Your ref:
Our ref: 24/00583/F
Please ask for: Mrs Lesley Raby
Direct dial: 01553 616818
E-mail: borough.planning@west-norfolk.gov.uk

Details: **Demolition of existing UPVC conservatory structure and erection of single storey rear garden room extension at Atherstone House Newton Road Castle Acre King's Lynn Norfolk**

ATHERSTONE HOUSE - CASTLE ACRE / PROPOSED NORTHEAST ELEVATION 27792/11

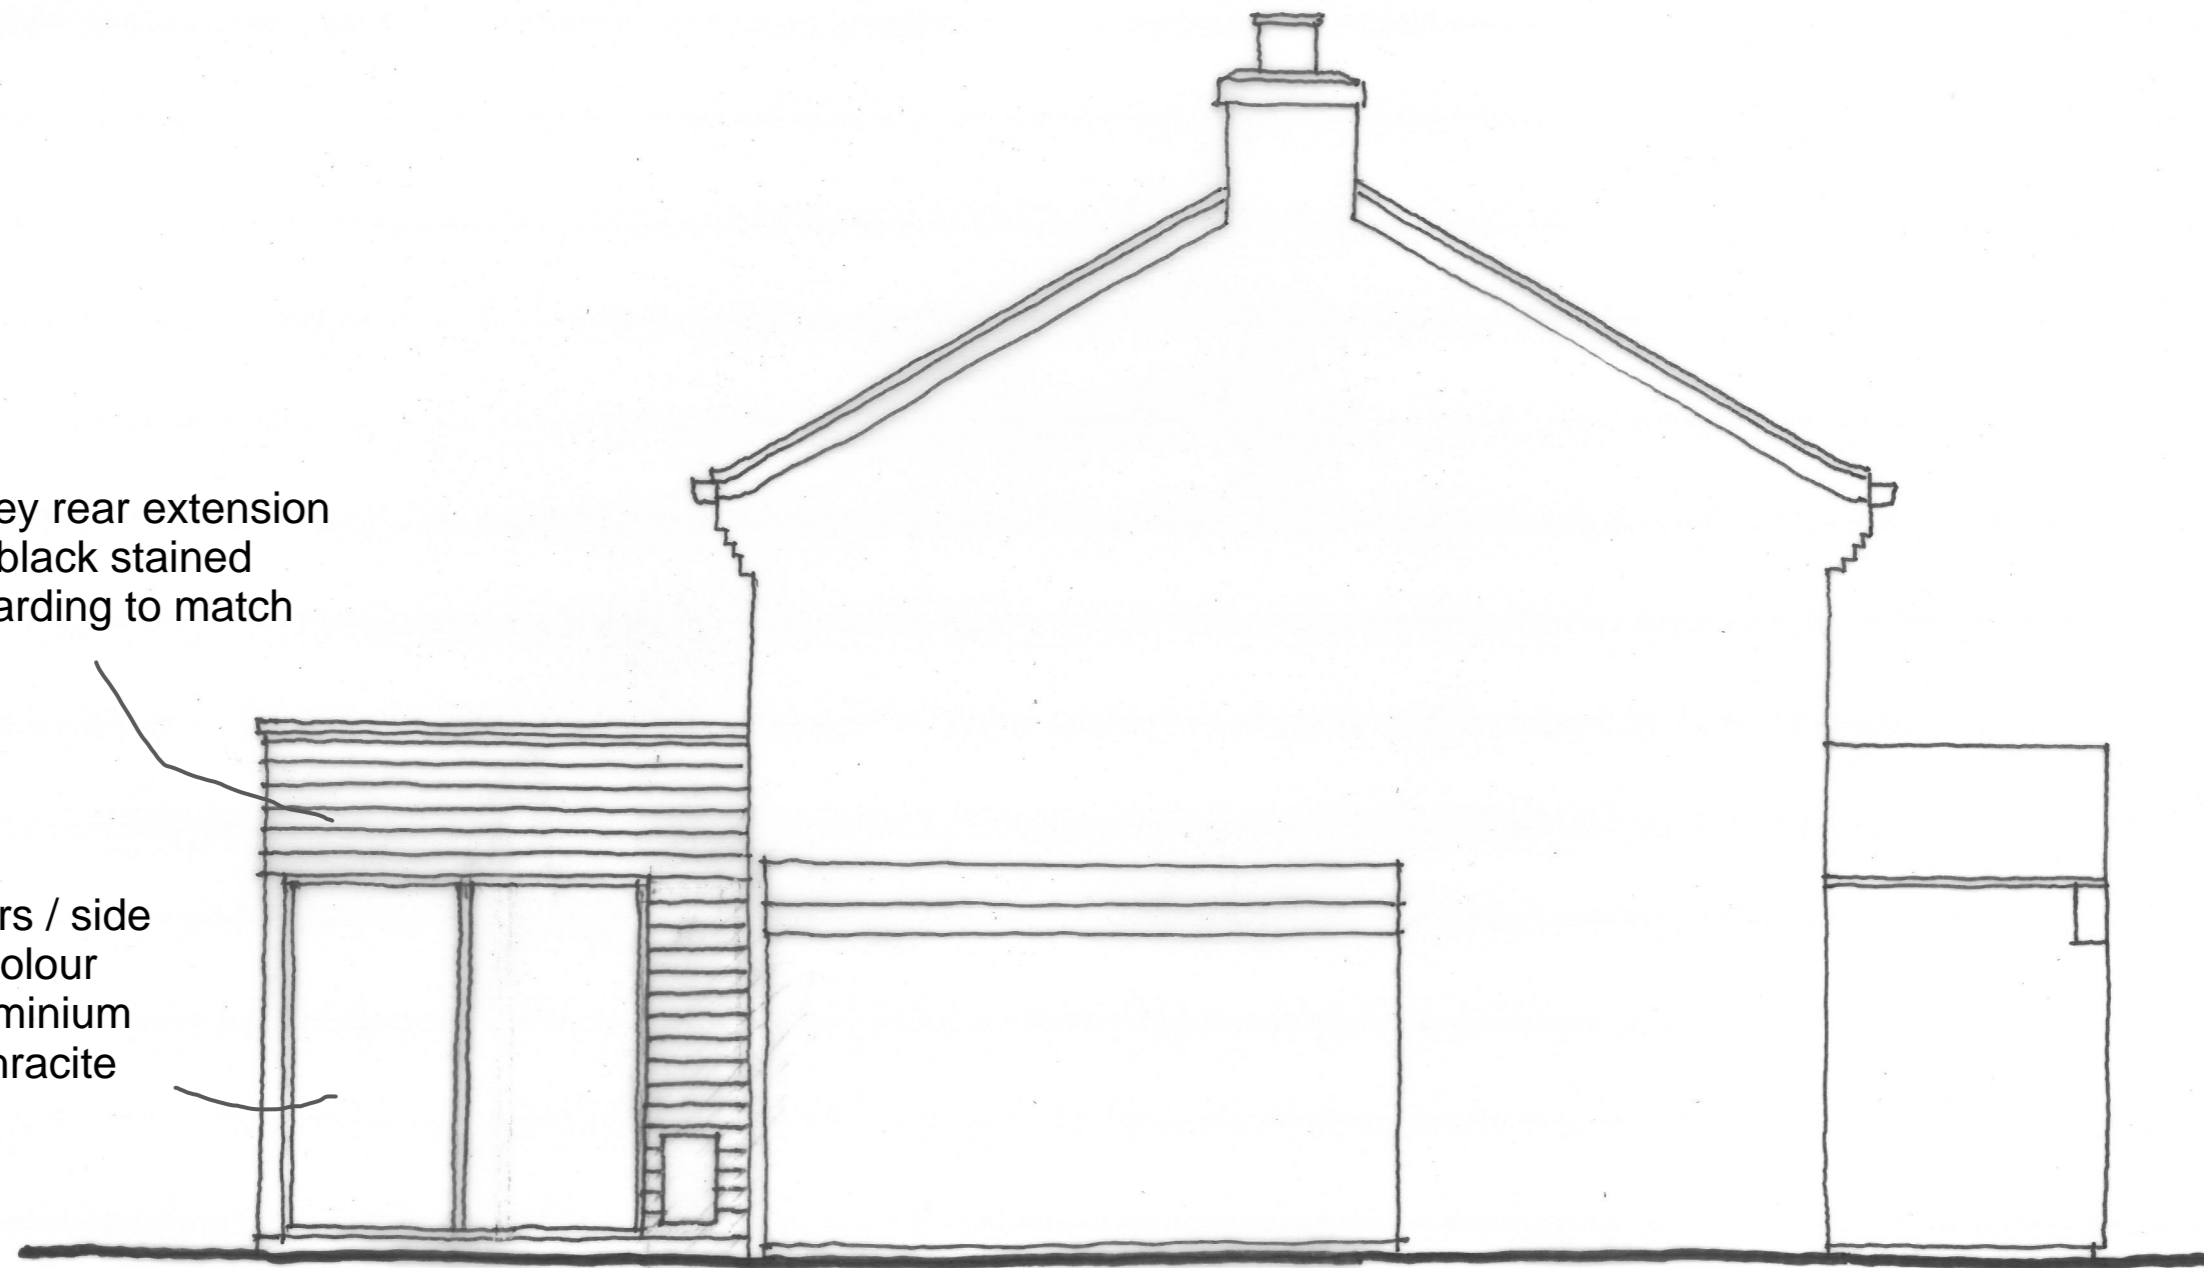
1. Confirm the site levels will remain as existing.
Confirm the finished floor levels will match the existing floor levels.
